Re: Review of Dargues Reef Gold Project, Major Project Application No. 10_0054

Southern Rivers Catchment Management Authority (Southern Rivers CMA) does not support the project as currently proposed in the Environmental Assessment, as submitted by the proponent, Cortona Resources Limited. A range of additional risk mitigation and environment protection measures are recommended to be incorporated into the proposal. These are outlined below.

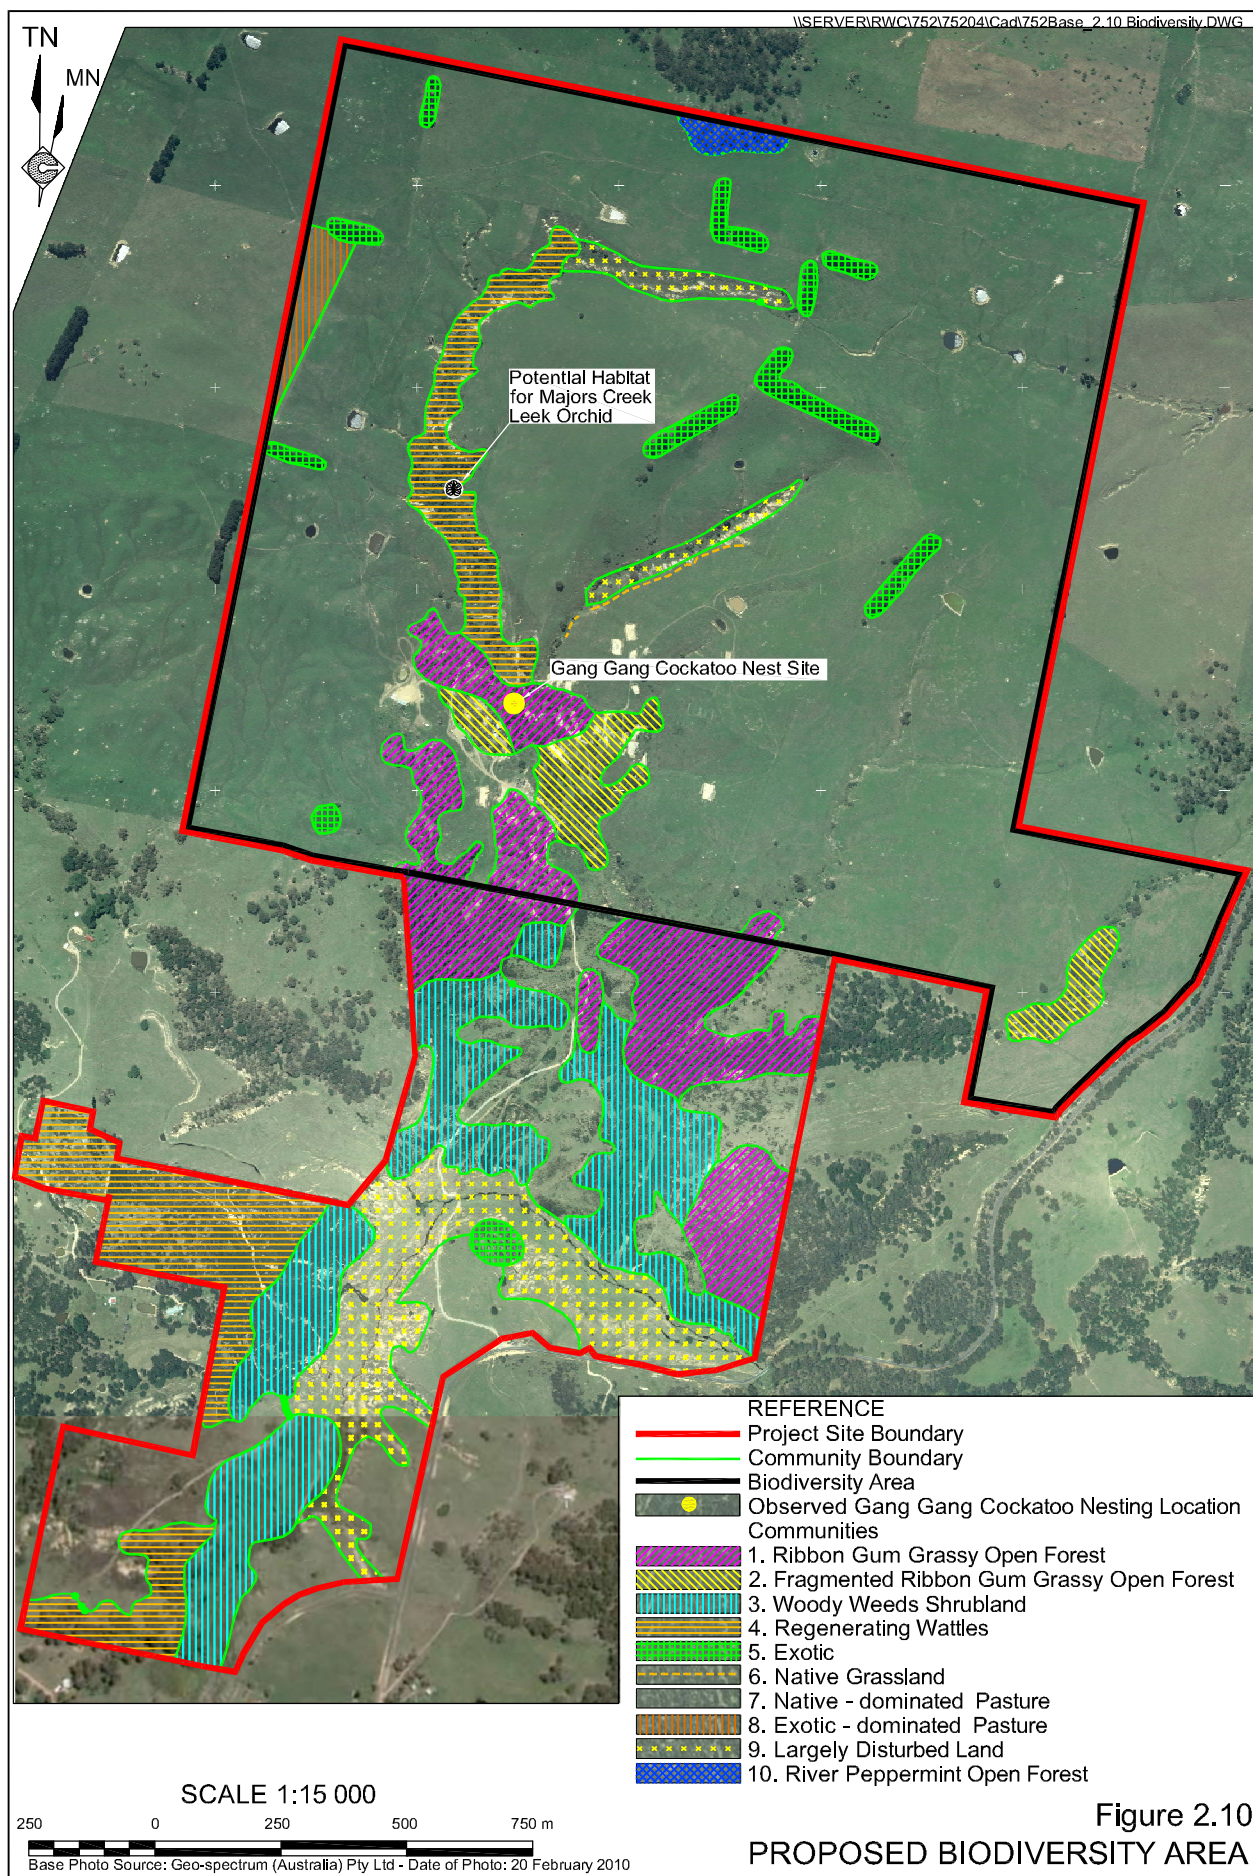
The proposed Biodiversity Strategy designates an area of land set aside in perpetuity for conservation values (i.e. a Property Vegetation Plan – PVP). Figure 2.10 of the EA indicates a 'biodiversity area' which is focused on the area of activity.

A Conservation PVP in perpetuity can only place on title areas that are to be 'maintained and improved', not areas that would be adversely impacted. The 'maintain and improve' outcomes assessment underpinning the Native Vegetation Act would preference a Conservation PVP over the remainder of vegetated areas of the entire property (grassland and woodland), not just within the proposed 'Biodiversity area'. The Conservation PVP area would be managed to improve the quality of habitat. As a minimum, the area would be fenced to exclude stock, with weed and feral animal control programs implemented and possible replanting in certain areas of the property. An indicative offset ratio of 1:20 would be appropriate for the impacts in question.
